Application for a Non-Material Amendment Following a Grant of Planning Permission

Rear extension with internal adaptations. New pitch roof to front porch. Replacement windows, new cladding and render to all external walls.
Proposed rear Balcony.

AW/338/19/HH

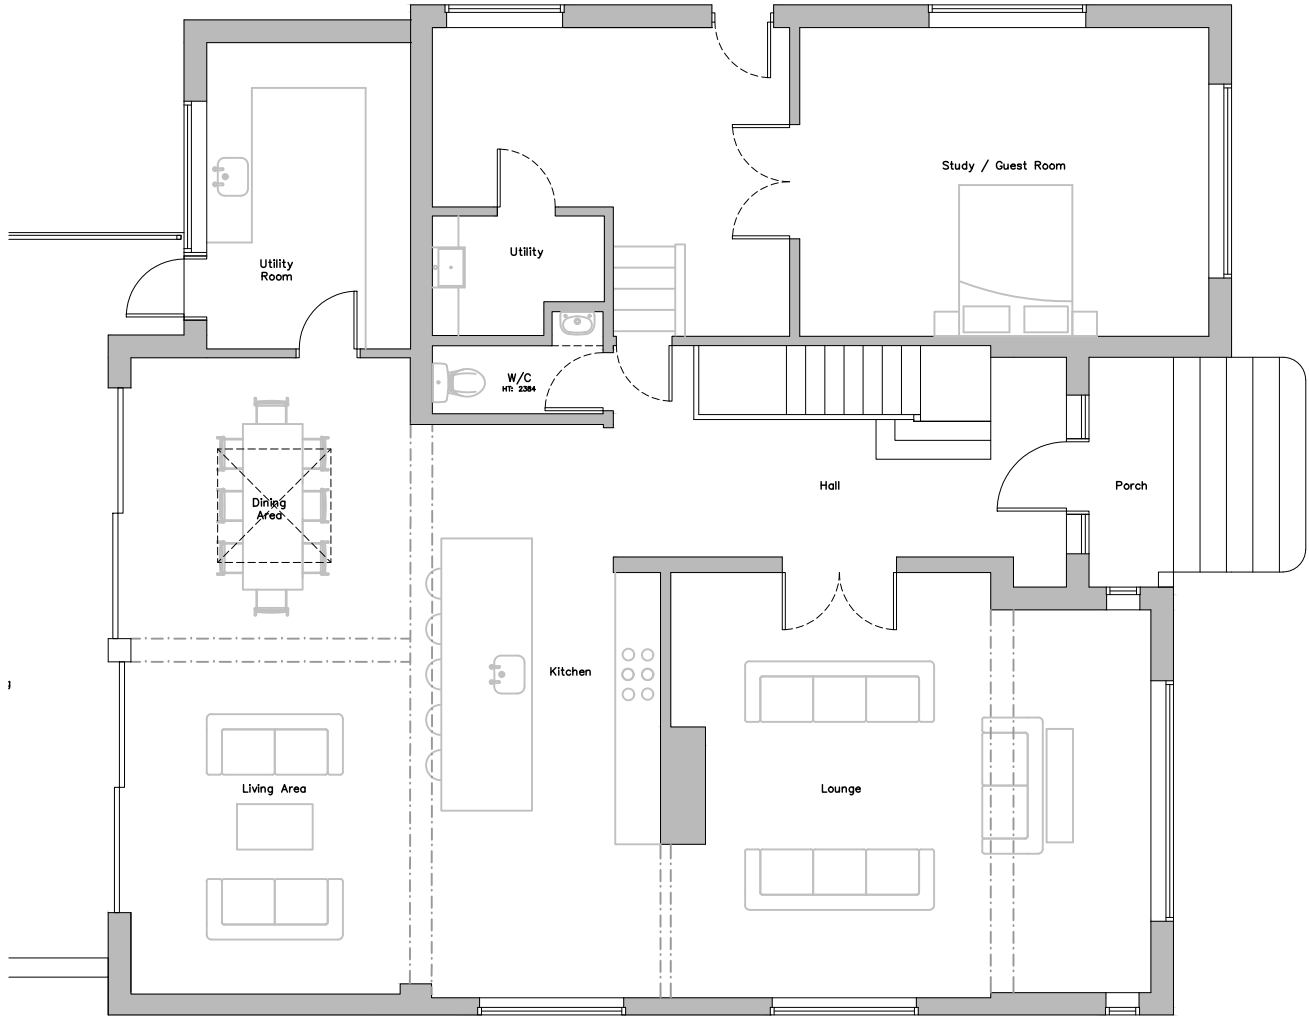
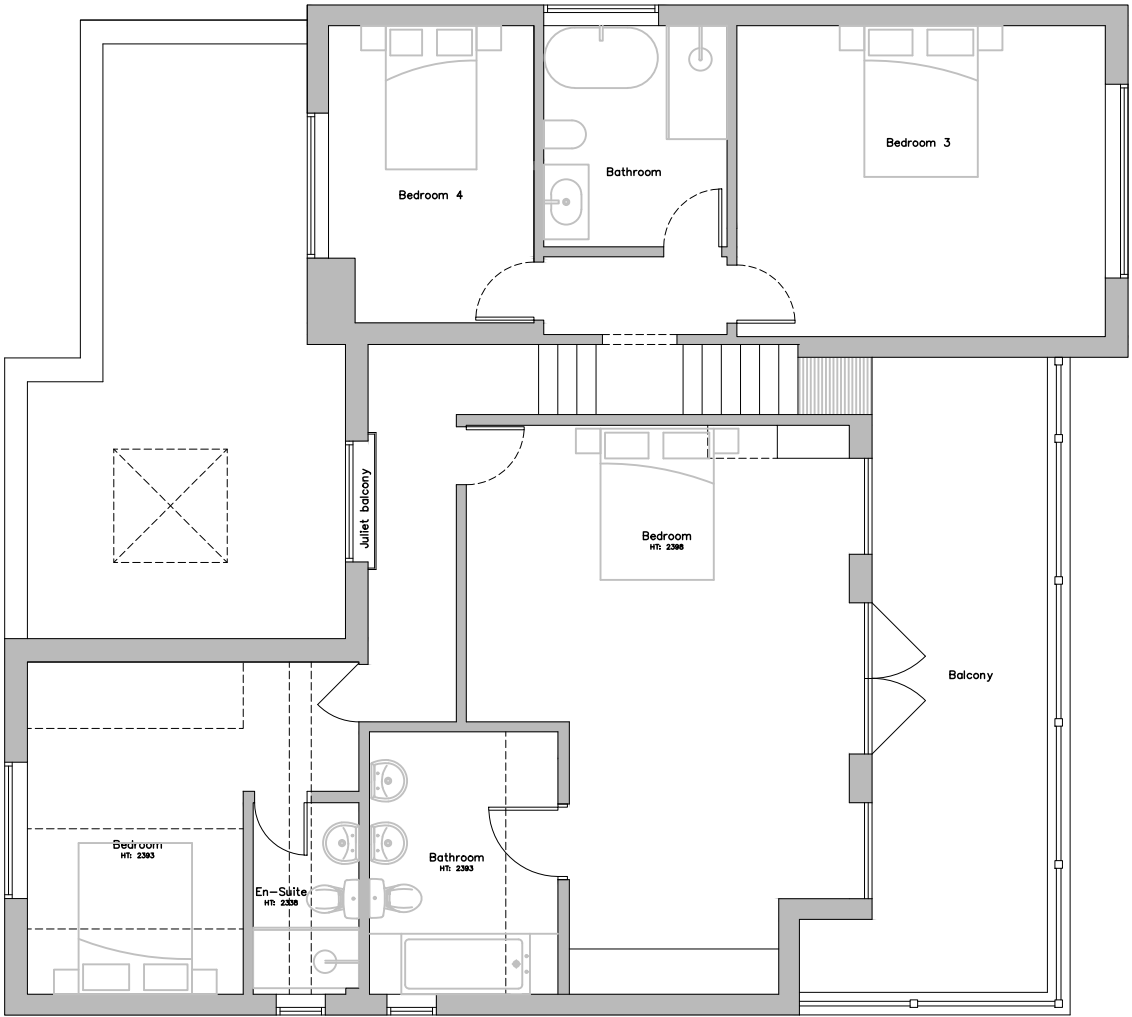
The replacement windows and doors have different fenestration, the extent of the new cladding and render to the external walls differs from the original application. The First Floor double doors to the rear balcony have been replaced with Juliet balcony doors. The balustrade to the front balcony has changed. The chimneys have been removed. New opaque screening has been added. The new rear privacy wall has been raised higher.
